Re: Addison Galaxy FBO Civil Plan Review

Development: Galaxy FBO  
Town Project #: 19-09D  
Plan Review: 1<sup>st</sup> Civil Submittal

Summary of Engineering Review Comments

SHEET NUMBER  
**C13.01**

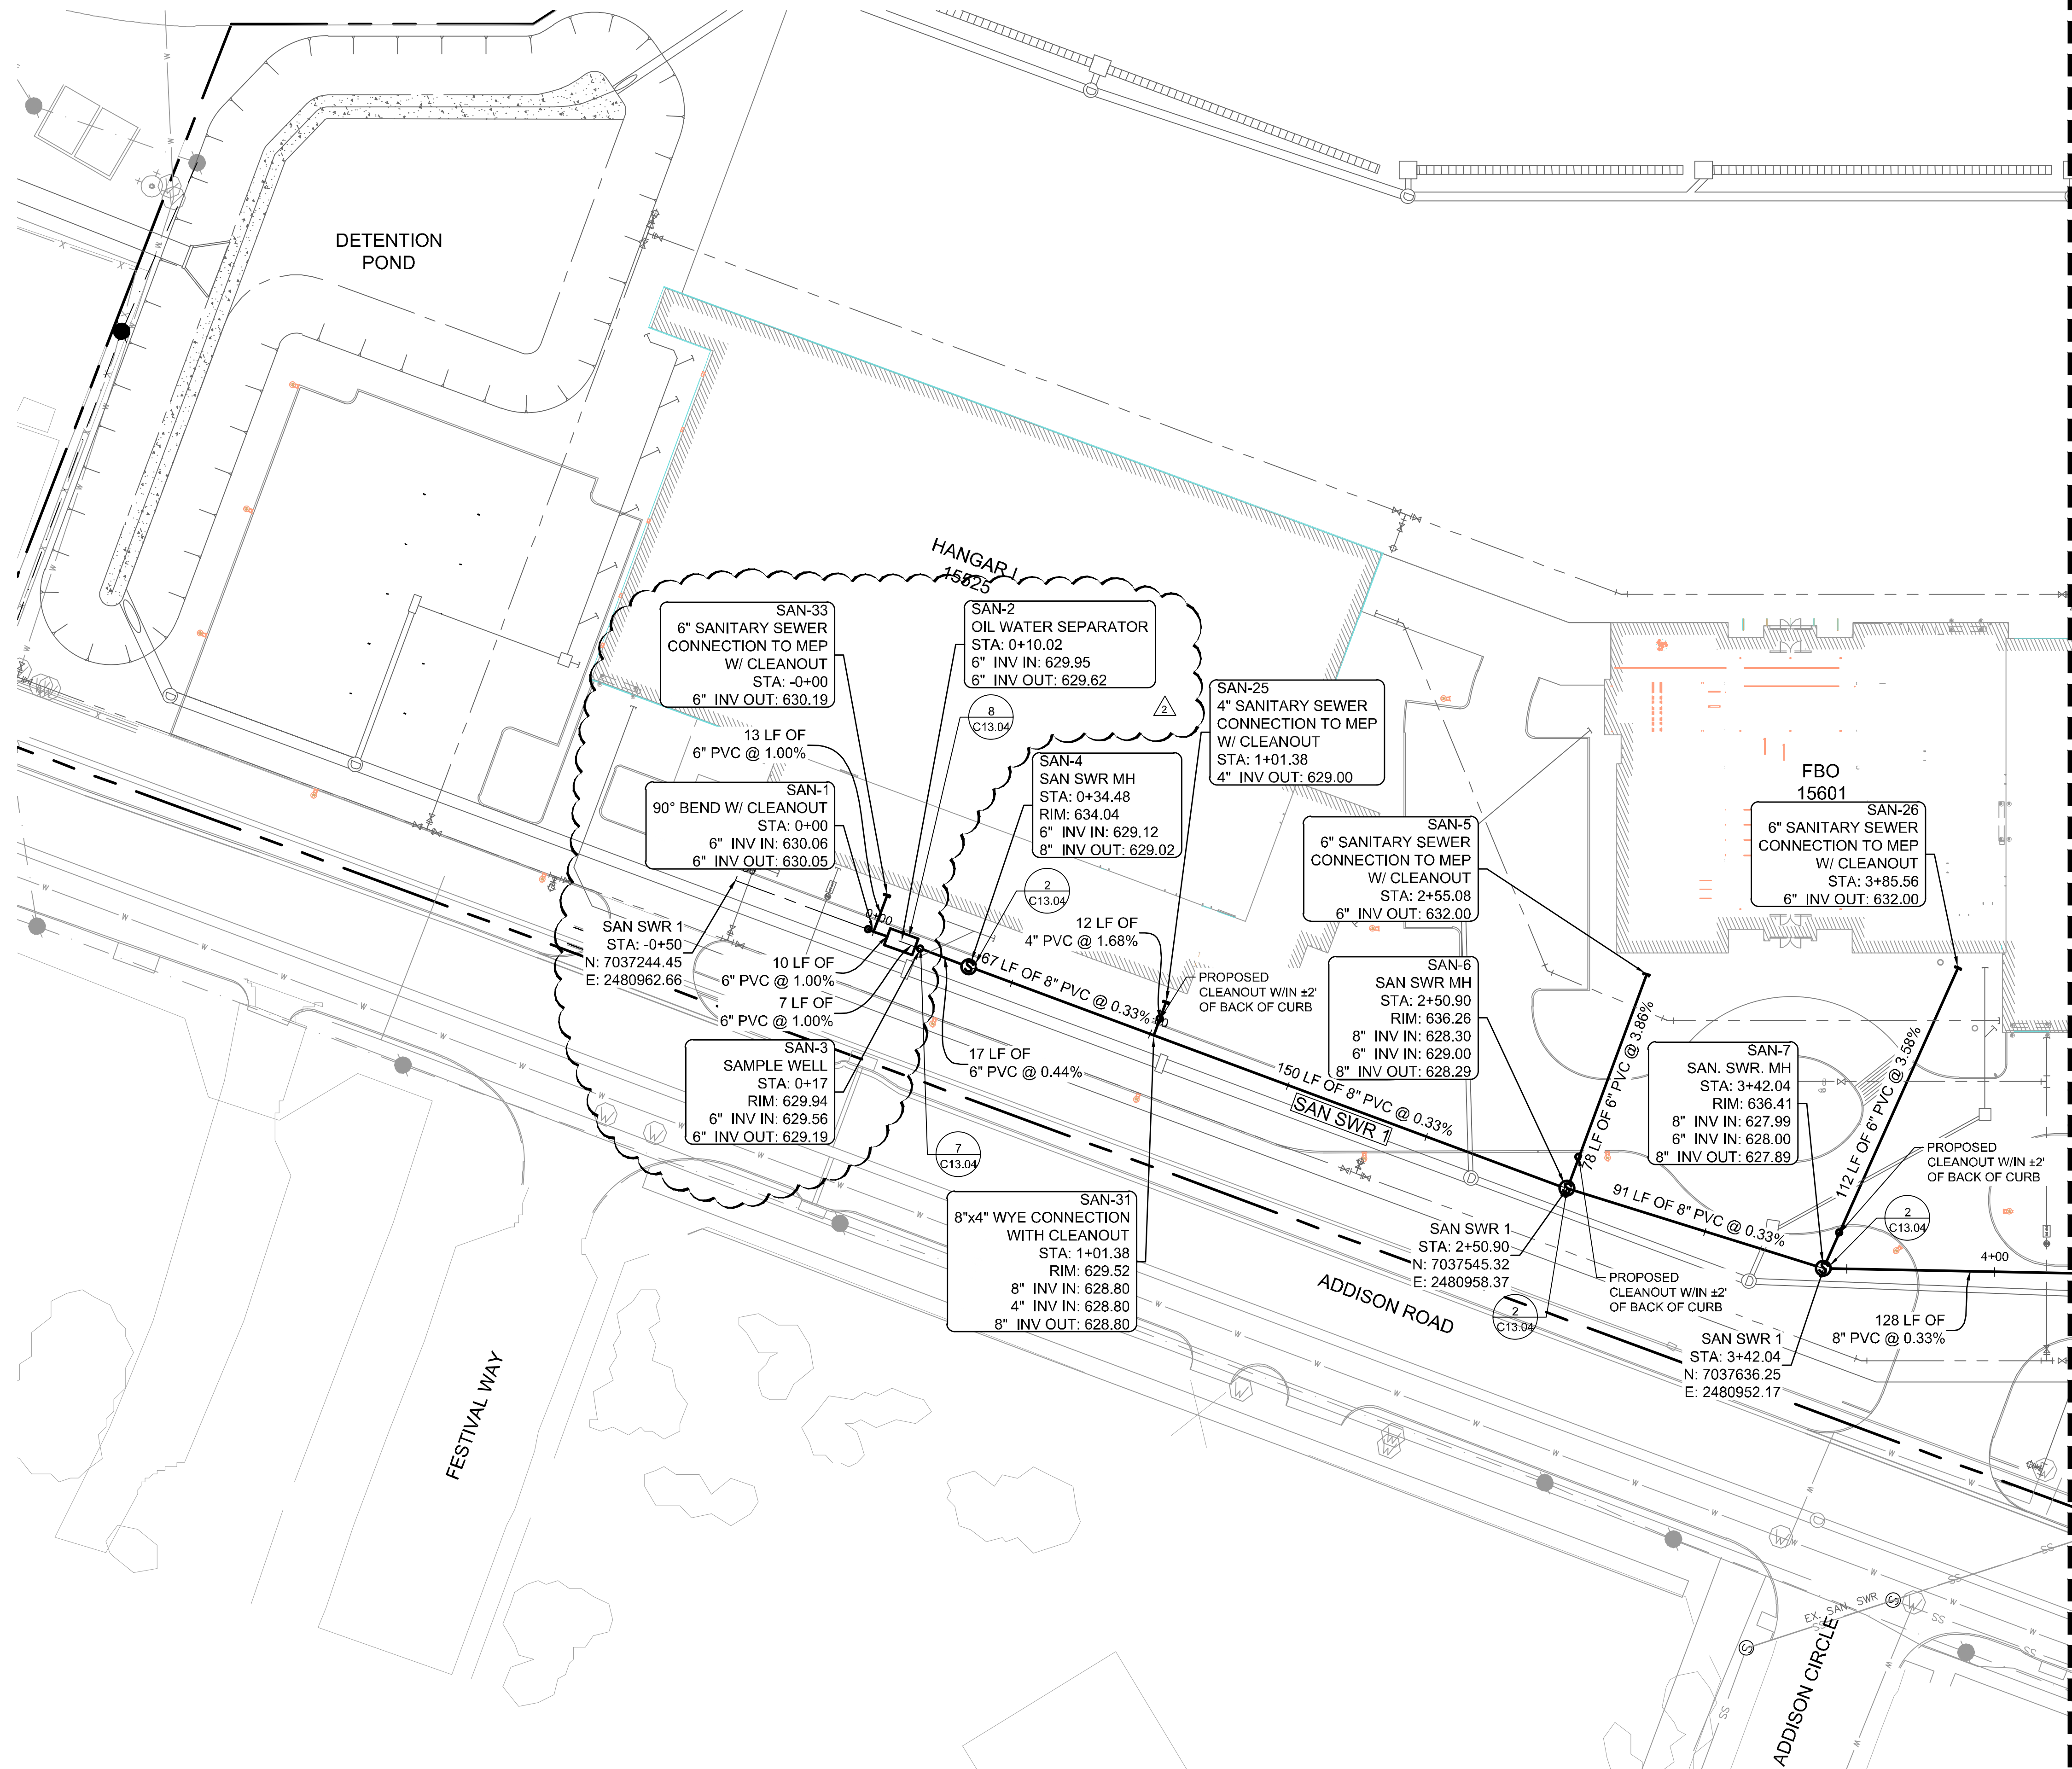
C13.01	Cleanouts at all bldg connections		
C13.02	Would like SAN-16 MH moved into drive & outside of the landscape island		
C13.02	Profile the dumpster service & show encasement where it crosses the water

SHEET NUMBER  
**C13.02**

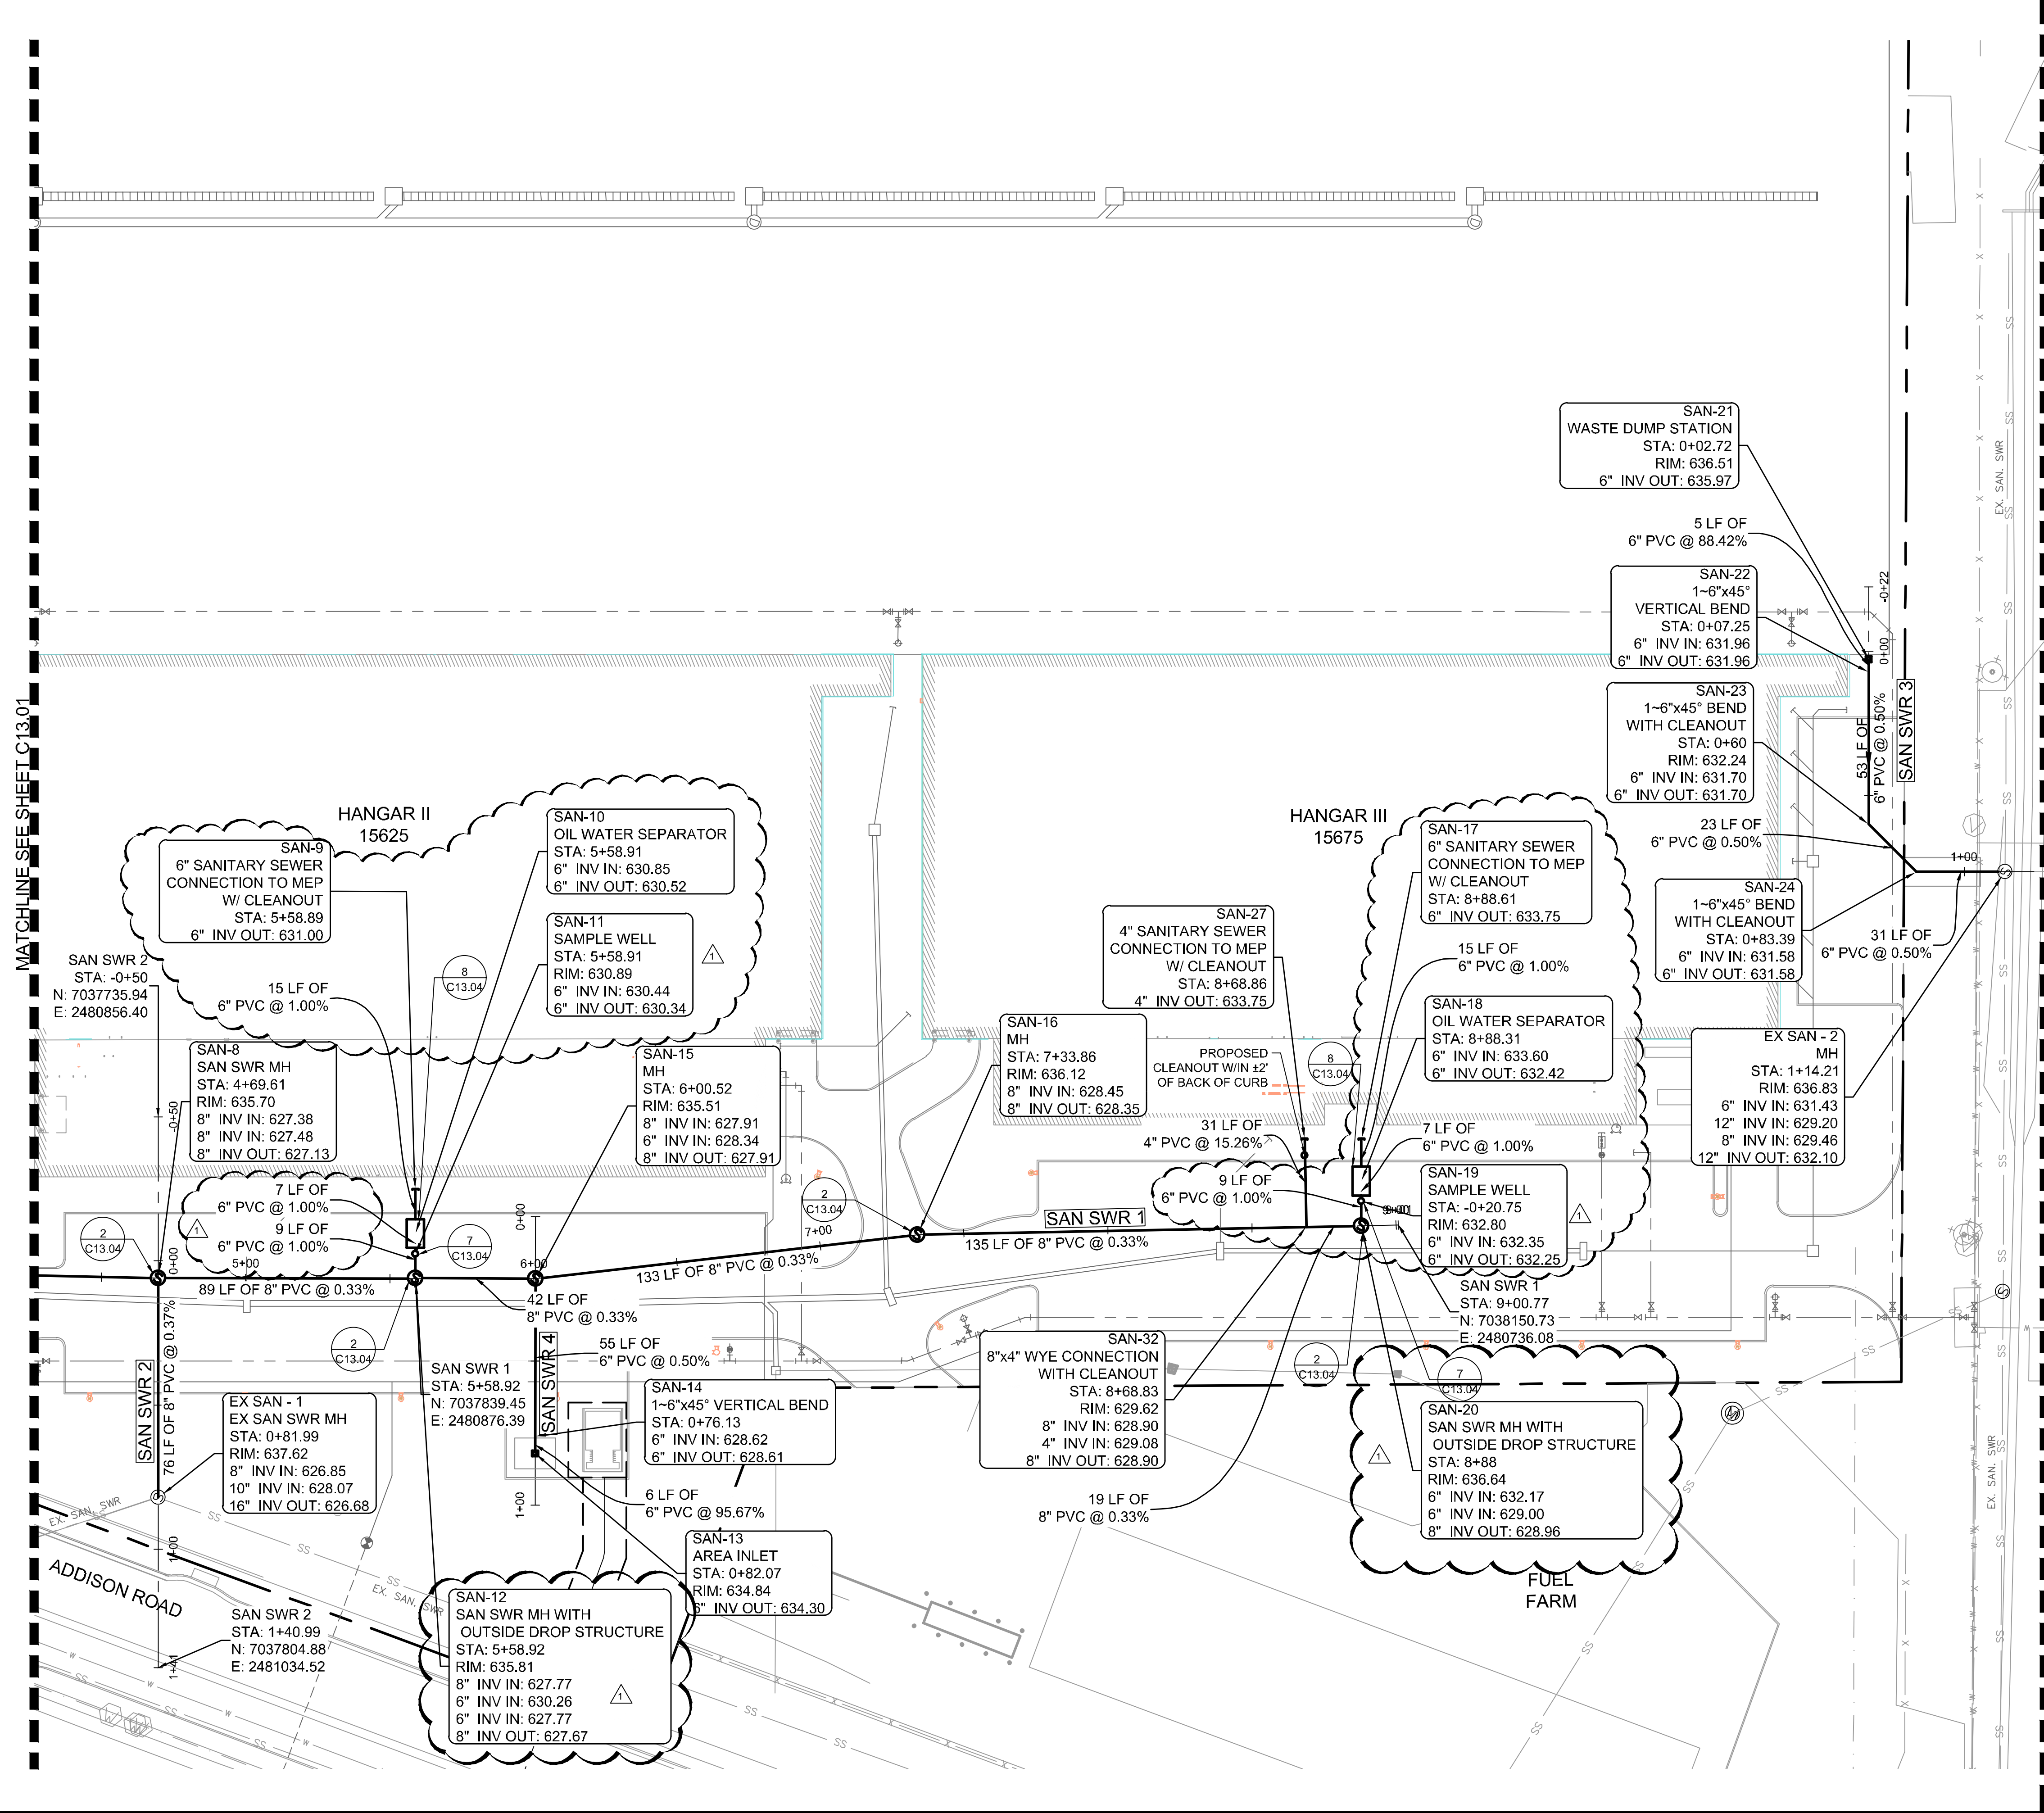
Page No.	Comments	Response (See Note)	Explanation
C13.02	Show & profile the new service that will be required for the discharge from the fuel farm oil/water separator, encase it where it crosses the water.		
C13.02	6" service connections require manholes @ main, not tees/wyes.		
C13.02	Car wash drains should be connected to sanitary sewer (b/c of soap/detergents), & should have oil/water separator (check with TOA Environmental Services & plumbing codes to confirm). If allowed to discharge to storm, will need another stormwater interceptor on the eastern trunk line downstream of the car wash lateral.		
C13.02	What is being dumped at the waste station at SAN-21? Does it need an oil/water separator also?		
C13.02	Put cleanouts at bends.		
C13.03	On shallow clearances between SD & SS w/ SD on top of SS, would like to see some kind of encasement (conc or steel) for those sections to protect against the weight and any future settling of the SD and SD embedment.
